Application by Rosefield Energyfarm Ltd. For an Order Granting Development Consent for Rosefield Solar Farm
NSIP Reference: EN010158

Natural England's Response for Deadline 3
Examining Authority's submission deadline: 27 May 2026

Annex 1: Natural England's comments following Issue Specific Hearings

APPENDIX 1B  
GREEN AND BLUE INFRASTRUCTURE PARAMETERS - PARCELS 1 & 1A

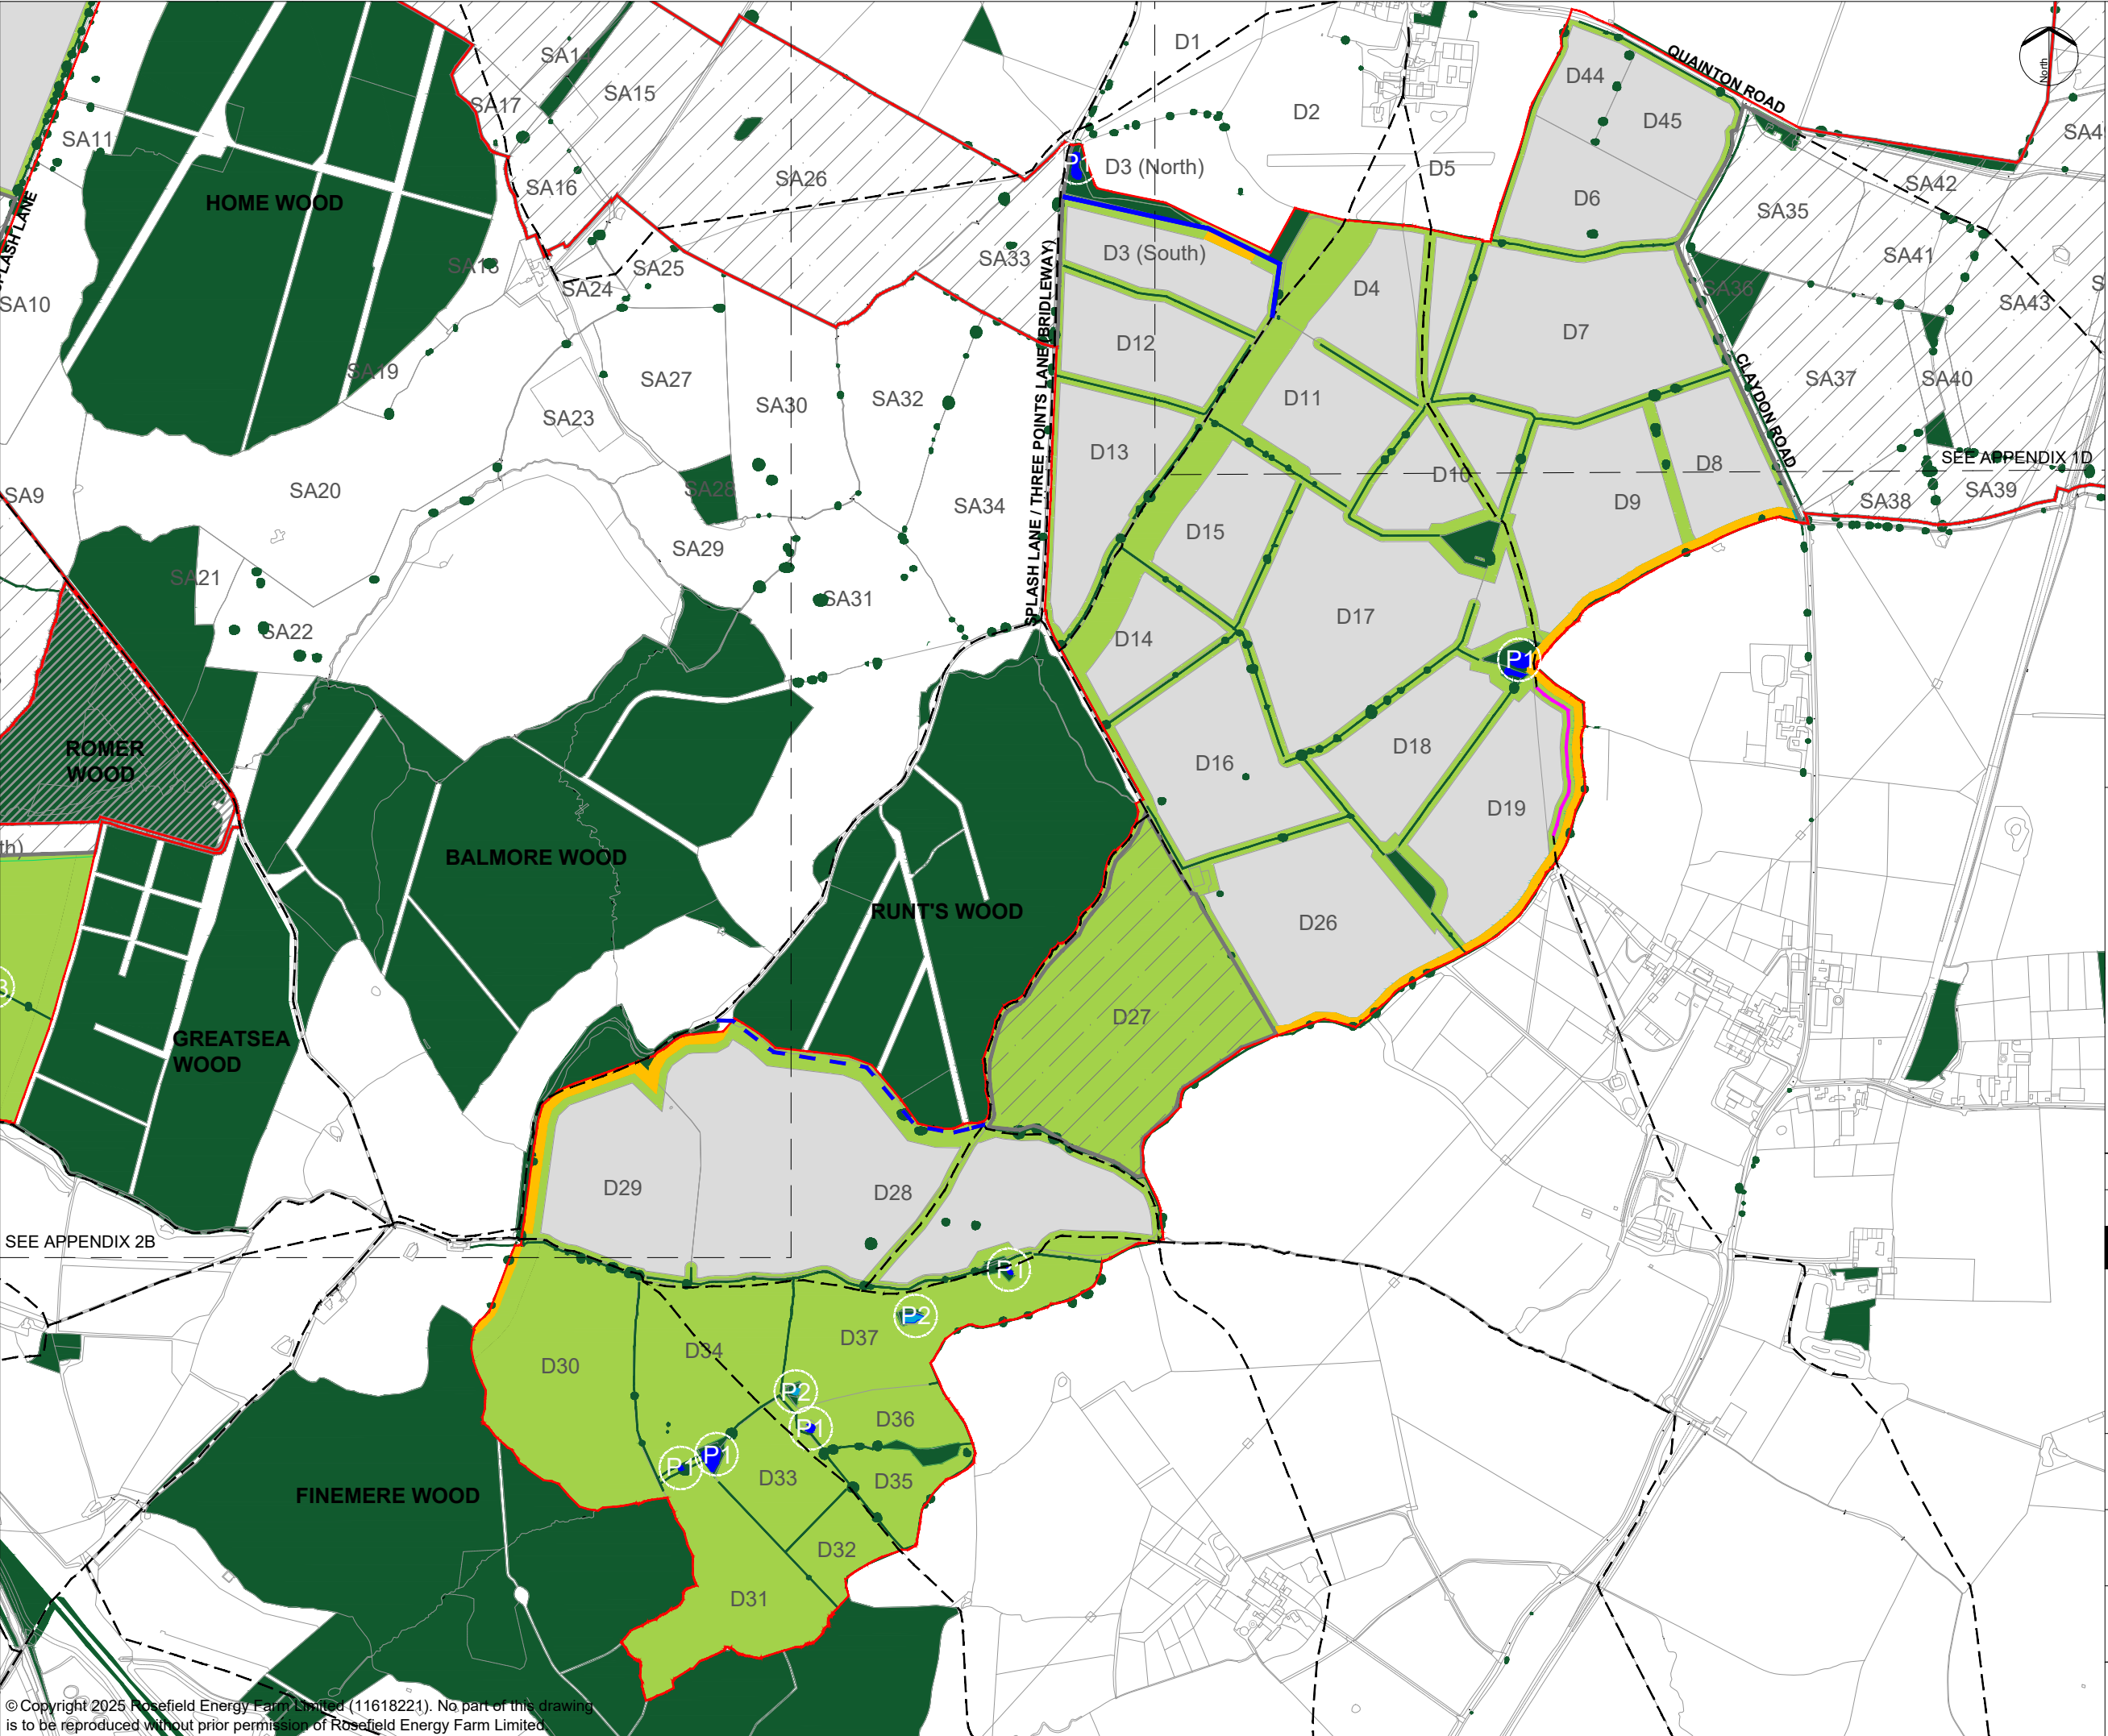
- 1.11 Based on the available data, summarised in NECR 558, as well as an assessment of habitat suitability we know that Fields B6, B7, B8 and likely also B3, are key foraging habitat for Bechstein's bats. This is recognised by the Applicant in their Responses to Relevant and Written Representations;
"It is true that habitat immediately north, east and west of both Decoypond Wood and Sheepphouse Wood SSSI has been identified as one of 'the most frequently used non woodland core foraging areas'" [PDA-006 para ref: RR-026 response on page 25] and *"The Applicant is aware that fields located between Sheepphouse Wood SSSI and Shrubs Wood form an important areas of the Bechstein's bat core sustenance zone."* [REP2-086 para ref: 2.1.39].

- 1.13 Alternative mitigation proposed in fields B9 and B17 is not adequate to offset the impact of losing the existing pastureland B fields, as these do not have the same underlying characteristics and geographical benefits. B17 is a hillside and has a much more exposed aspect than the western B fields, which are low lying and sheltered. Fields B6, 7 and 8 are also especially sensitive in that they link three areas of ancient woodland; Decoypond Wood, Shrubs Wood and Sheepphouse Wood. Two of which have known Bechstein's roosts, and all of which are used for foraging and may support other roosts that have not been identified. Given that surveys can never be completely exhaustive and only ever represent a snapshot in time and a subset of the population, there is a high likelihood that Sheepphouse Wood supports maternity roosts. Access to high quality foraging resource and habitat in close proximity to roosts is important for sustaining the population and the loss of fields B6, 7, 8 may reduce the suitability of the three woods to support future roosts.

- 1.18 Whilst an avoidance and appropriately sited mitigation approach has been adopted in Parcel 1a and largely in Parcel 2 (i.e. the C and some of the D fields), it has not in Parcel 1 (which encompasses the B fields) where the development of existing pastureland remains.

- 1.19 We recommend that the avoidance approach is adopted consistently, with all grazed fields protected from development throughout the order limits. Enhancements should focus on the retention of grazing as well as increasing the proposed buffers. This would not only protect current use and value, but also to ensure future resilience is not compromised on a scale and geographic spread that recognises the value of this existing habitat and the National importance of the Bernwood Bechstein's population that it supports.

- 1.21 We recognise that the width of buffer zones along hedgerows in Parcel 1 fields have been increased by 5m either side (i.e. from the standard 10m up to 15m) to increase the likelihood of the hedgerows continuing to provide connective links between the blocks of ancient woodland. We recommend this should be in addition to, as opposed to instead of, the continued provision of grazed pasture in this area. This would complement and reinforce the benefit from creating and retaining grassland elsewhere within the site, making it less likely that Bechstein's bats will be significantly adversely affected by the proposed development.

TITLE:
APPENDIX 5A
GREEN AND BLUE INFRASTRUCTURE PARAMETERS
BUFFER WIDTHS - KEY PLAN

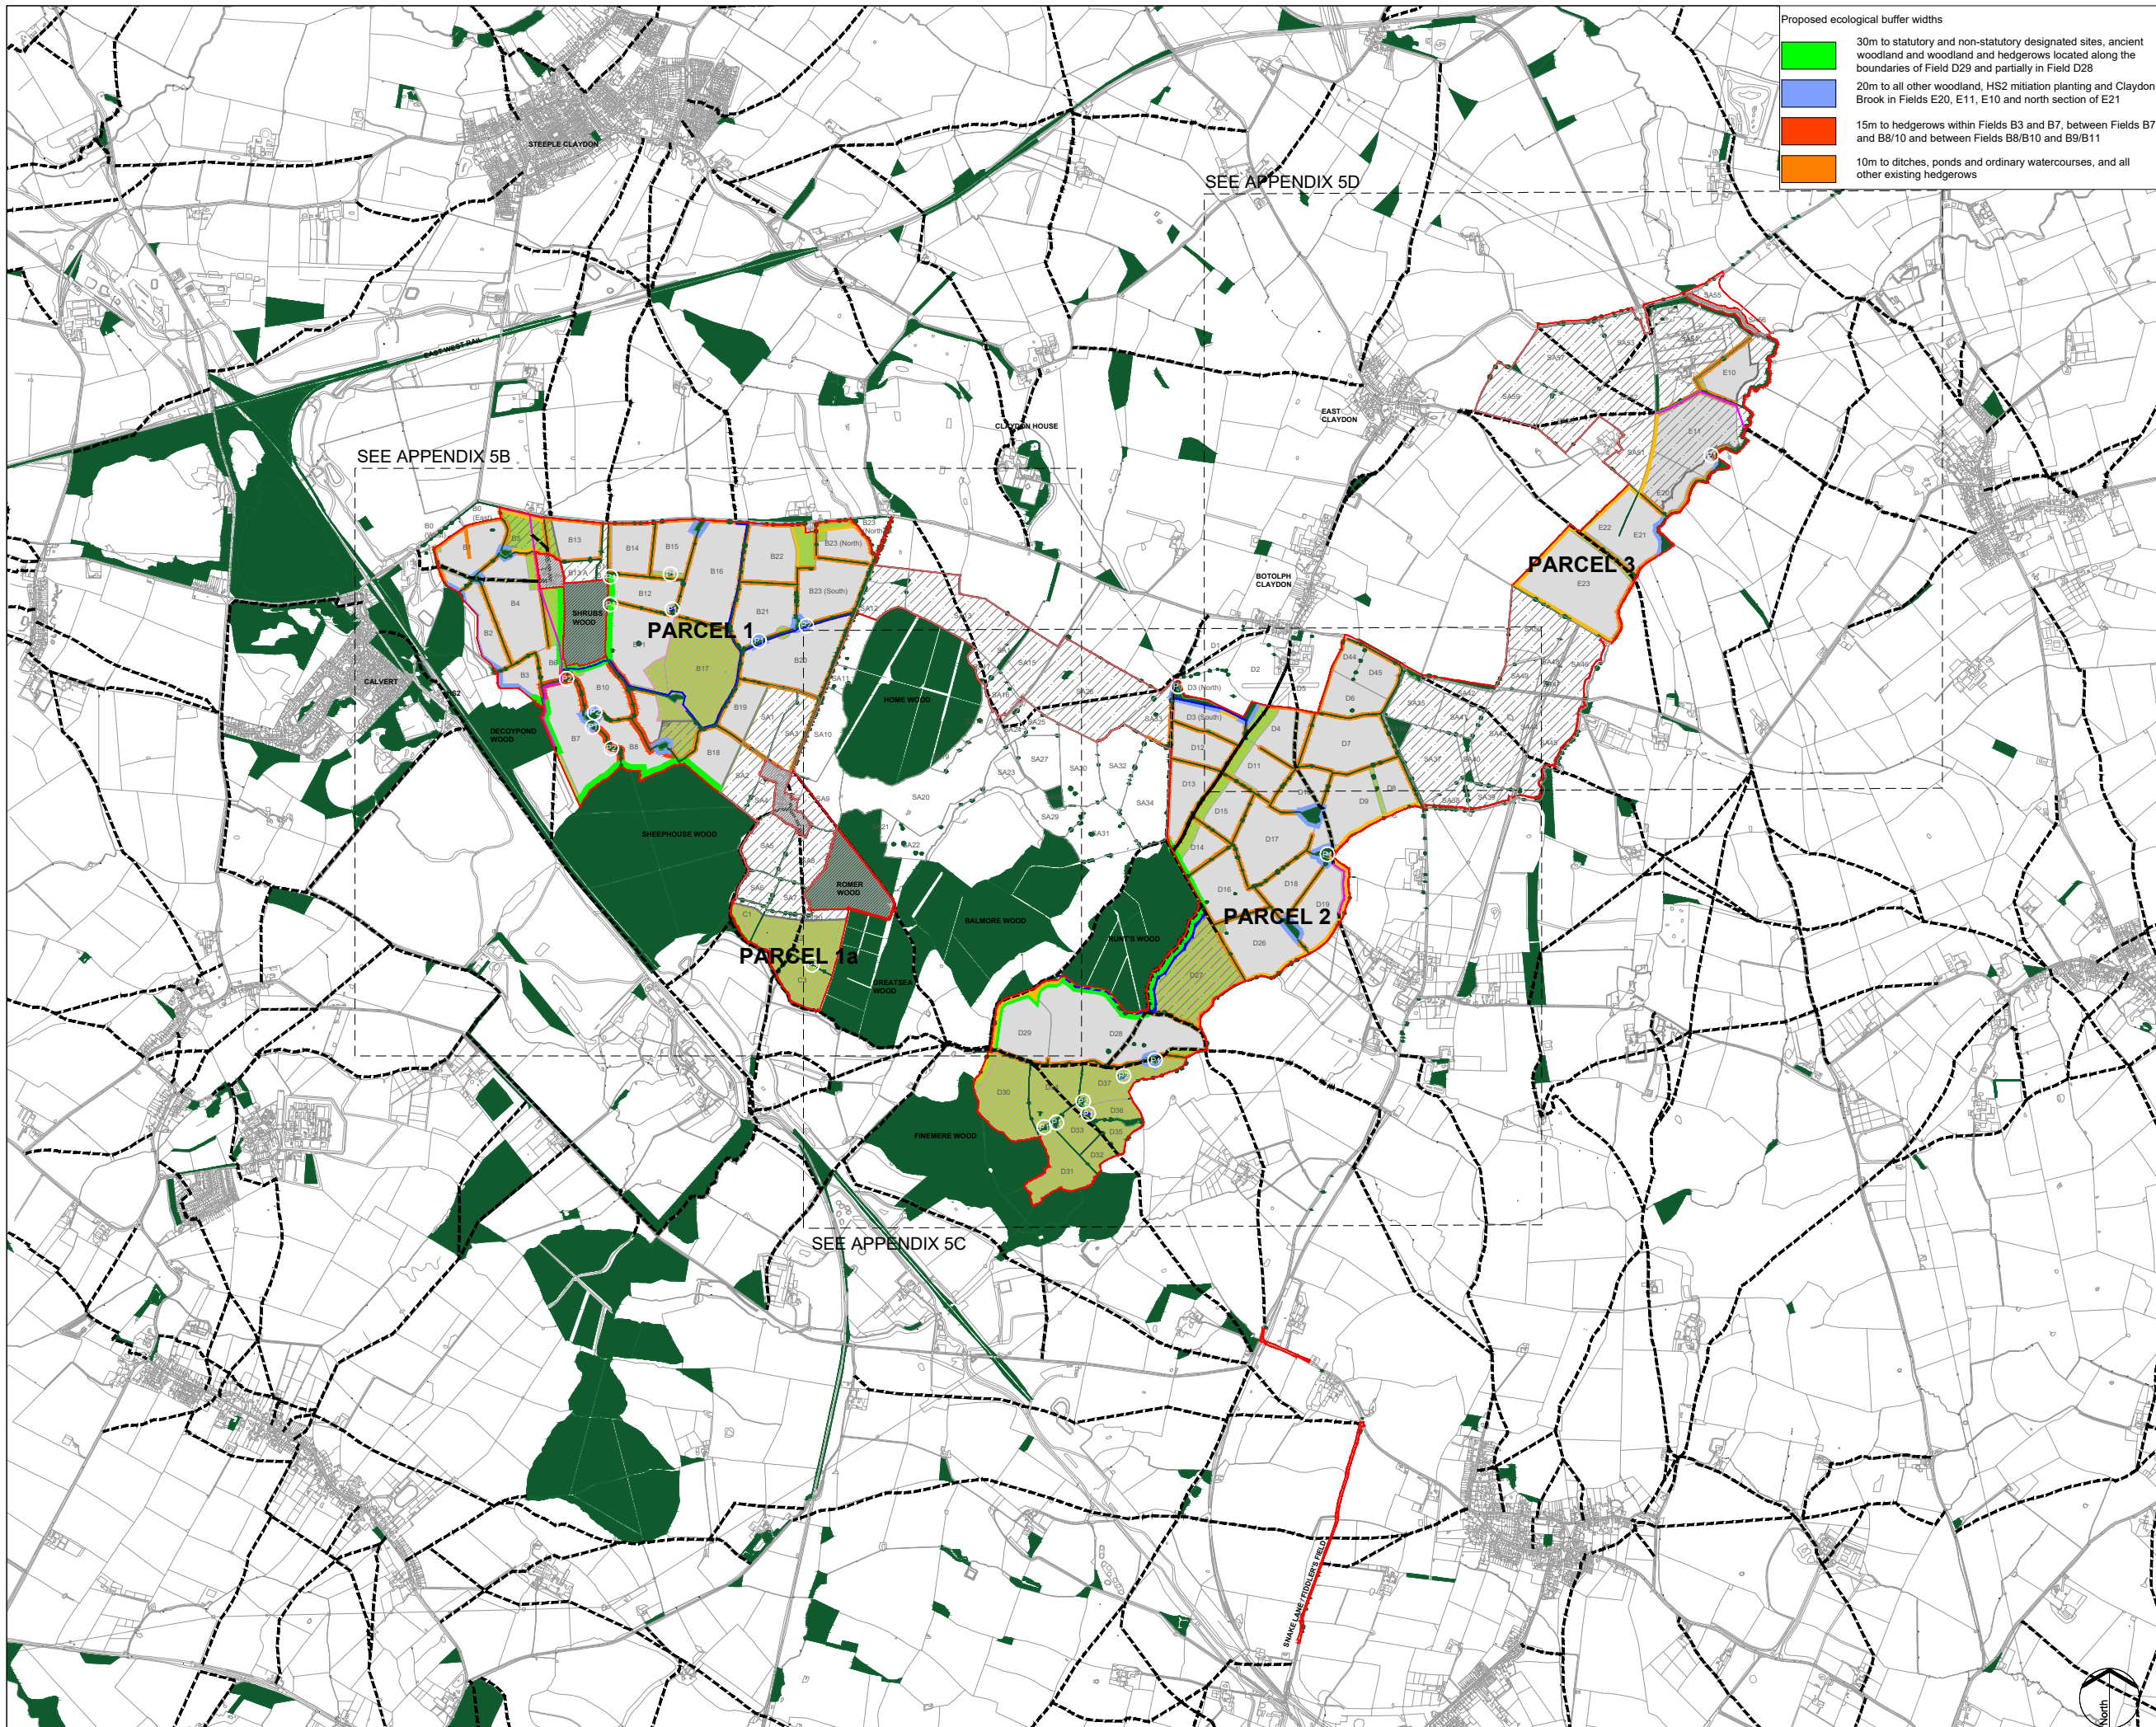
- 1.25 Natural England advise that buffers should not be measured from a centre line of existing hedgerows but be based on an agreed width (10-15m either side of a field) on top of the existing ecological features representing the baseline conditions. If this approach is not implemented, then many of the proposed buffers will simply protect the existing hedgerow ground flora or field margins and may not extend as far as tree canopies where there are large hedgerow trees. We do not advise that these buffers must be re-calculated post construction, just that the baseline is captured at a set point of time and the buffers are additional to existing features. This approach was recently agreed on the Botley West Solar DCO (currently still in examination).

- 1.26 Given the uncertainty of effectiveness of hedgerow buffers, we have advised a precautionary approach. We continue to recommend that the proposed buffers are additional to existing features in the landscape.

- 1.27 In various documents submitted to support the application (e.g. response to Q1.7.7 [REP2-087]), an argument is made that because the Bechstein’s bat has a relatively small echolocation range (approx. 15m), then a 15m wide buffer ensures solar panels would not pose any impact to the bat. We wholeheartedly disagree with the various statements made suggesting buffers will be adequate because they are wider than the distance over which the echolocation calls of Bechstein’s bats are likely to operate. Firstly, we do not know the distance over which any bats can hear, either their own echolocation or when they are passively listening for prey, we only know what we can detect using our equipment. Bechstein’s are a quiet species, but they also have large ears and will utilise passive listening when hunting prey so this may contribute to their reasons for only emitting quiet calls. Secondly, bats have good eye sight and good memory they use their senses to extraordinary effect, which we do not fully understand. They will be fully aware of what is present beyond their echolocation range as they travel around their home range. For example, they can remember the location of a hibernation site that they may only visit a maximum a few times a year, or even only once for some species and they can travel large distances well beyond their usual home range to access it. Lastly, bats do not fly in a straight line, so measuring what is a suitable distance beyond the expected range of their echolocation would not be able to follow exactly where they are flying.
